Planning Application Ref: 3/2019/0483

Description of Development: Temporary Equine Workers Dwelling & Equestrian Building (resubmission of application 3/2019/0229 & 3/2019/0222).

Site Address: Land Adjacent to Woodfold Hall, Further Lane, Mellor BB2 7QA

Proposed Site Plan - 1:500

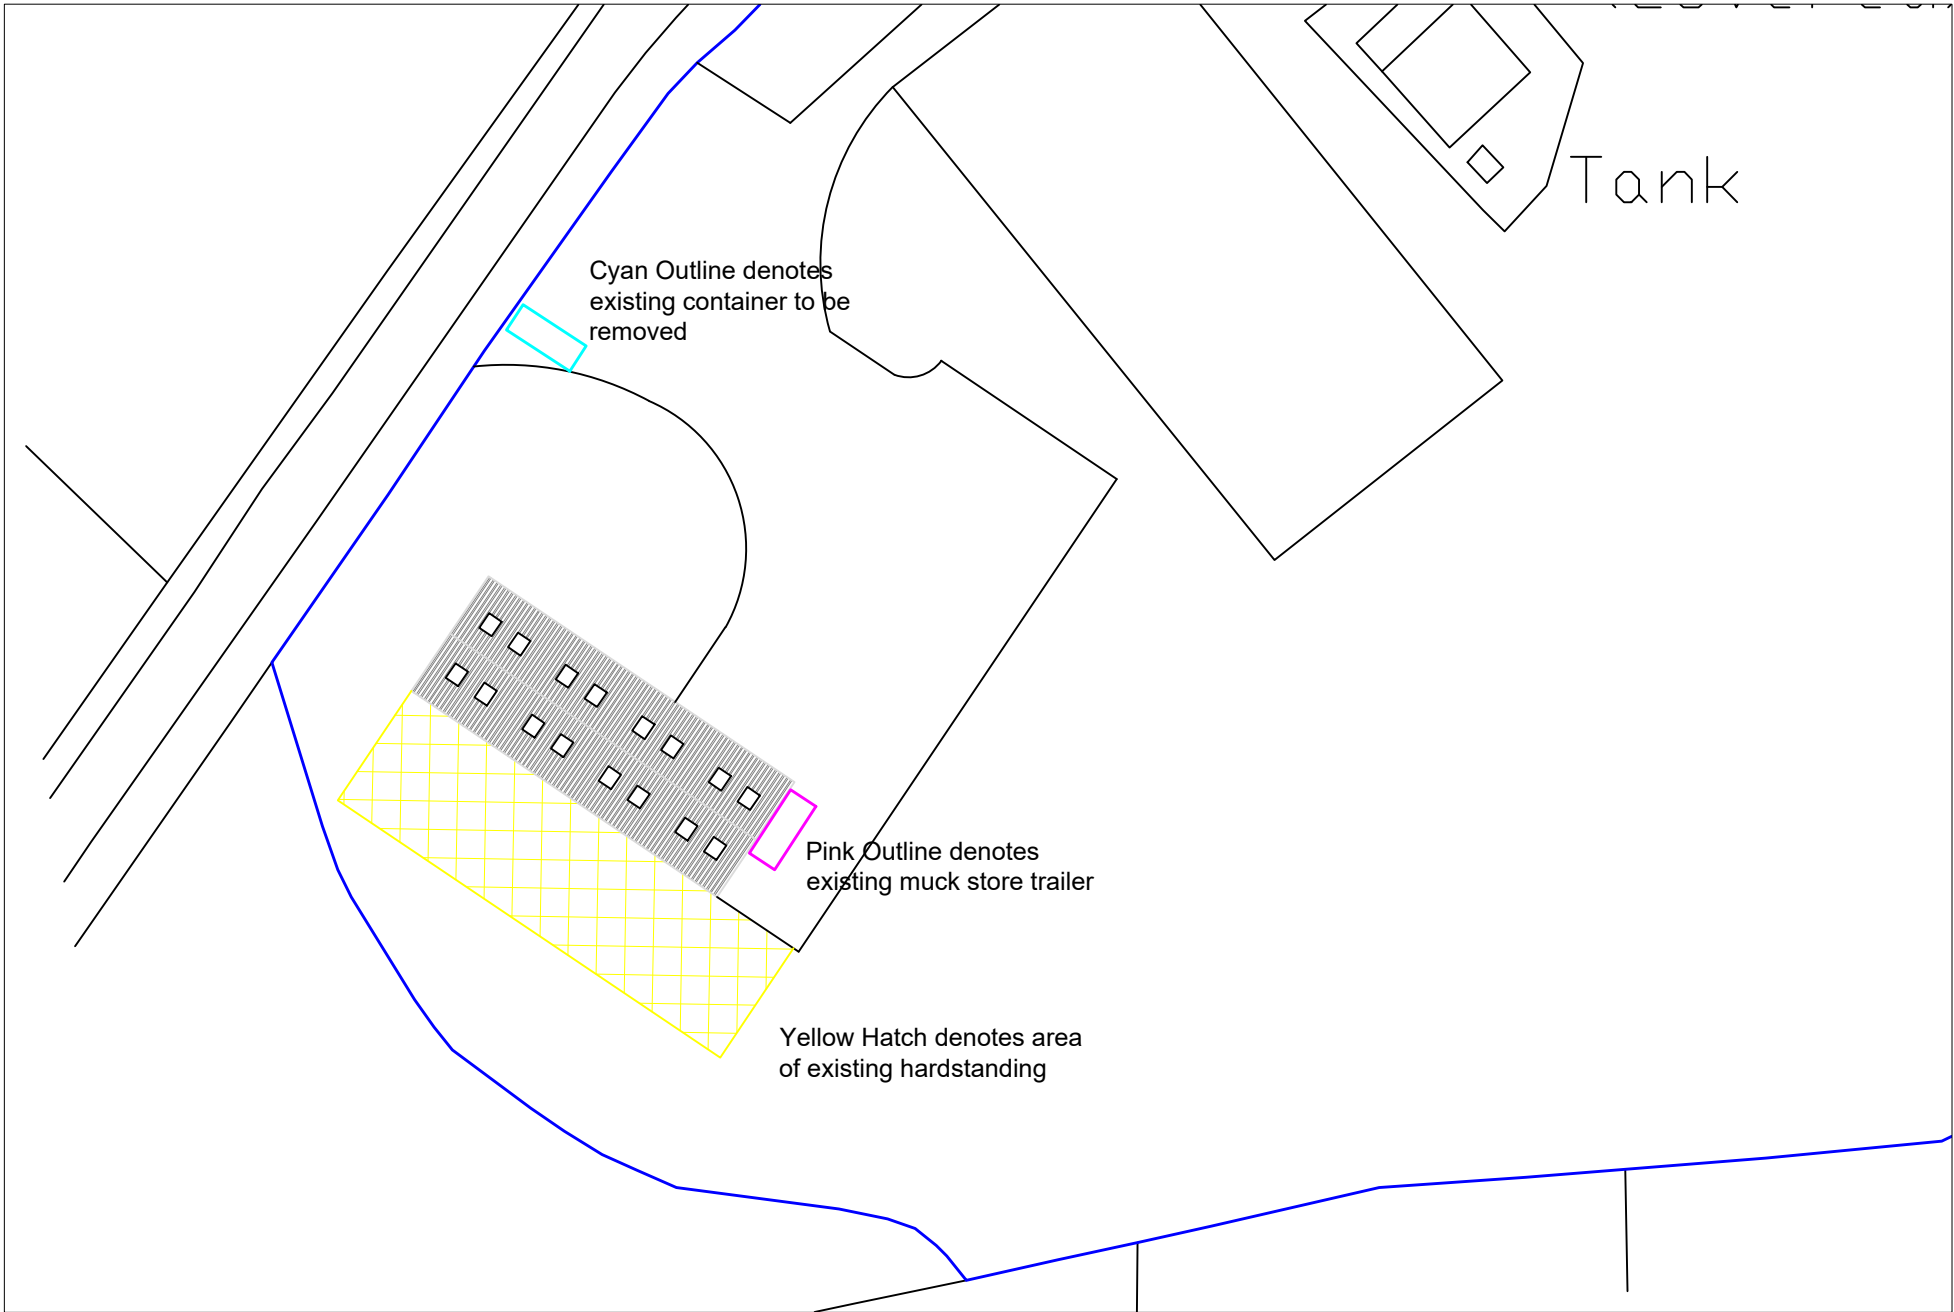
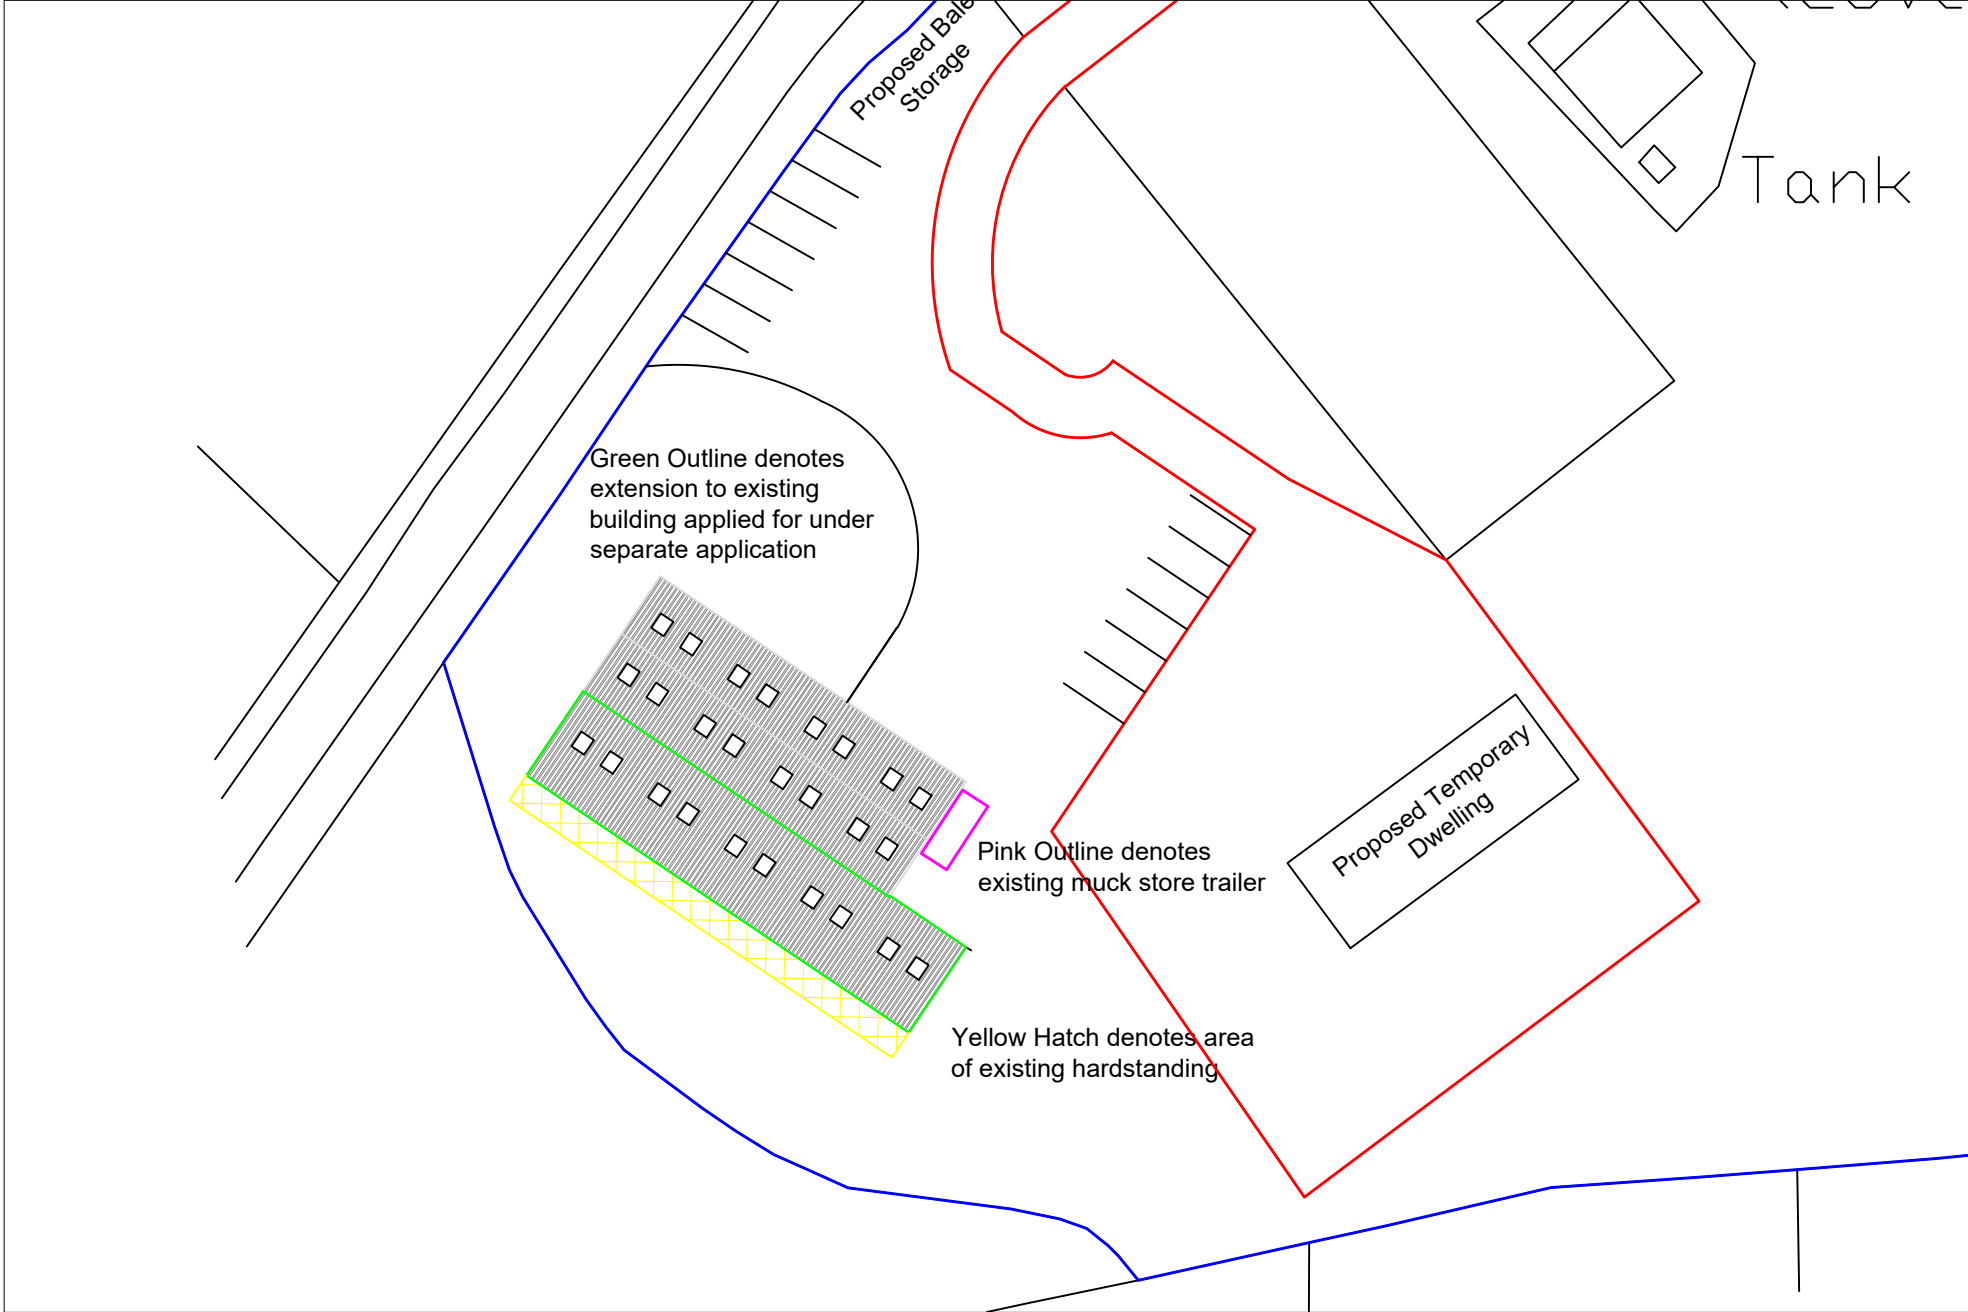
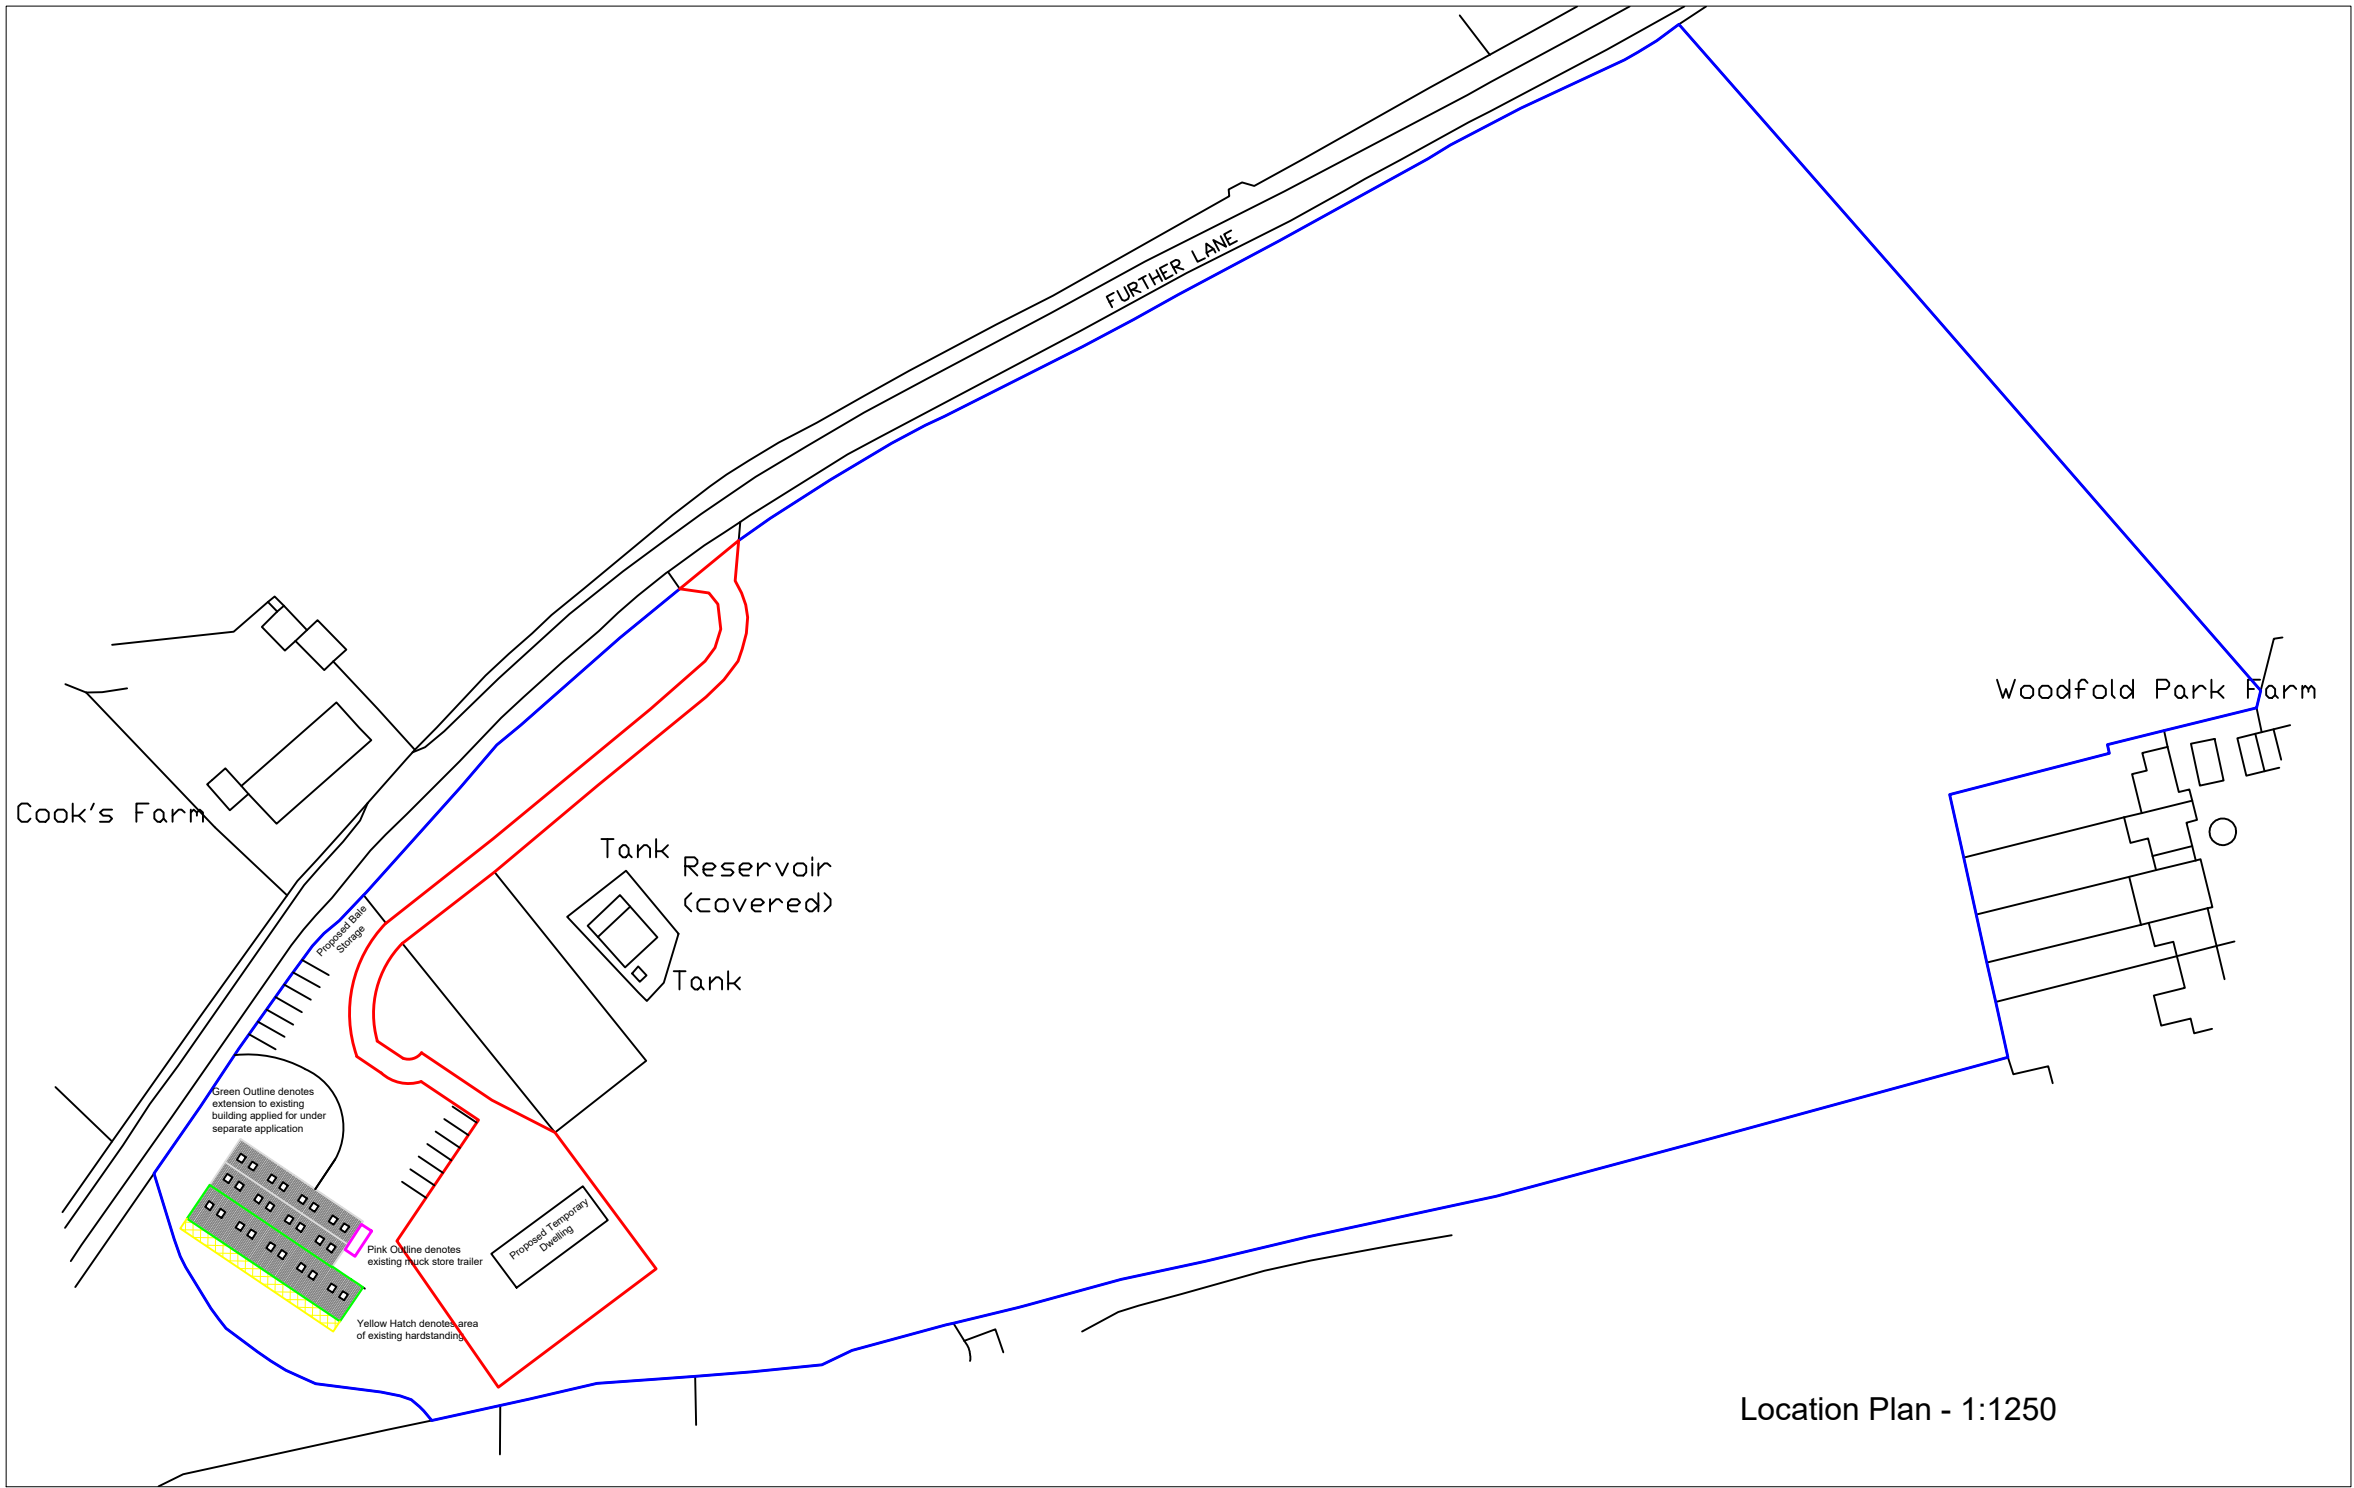
The proposed location is also considered suitable in terms of being located within reasonably close proximity to the stabled horses i.e. within 'sight and sound'.

The plans submitted along with this proposal demonstrate that the development will be situated some distance away from existing structures located at Cooks Farm, to the northwest. It is considered that this siting does not restrict the detrimental impact of the proposal on the openness of the Green Belt. It is considered that the evidence in favour of this development supplied in this application does not outweigh the harm that this development will do to the openness of the Green Belt, and should therefore be considered to be inappropriate.
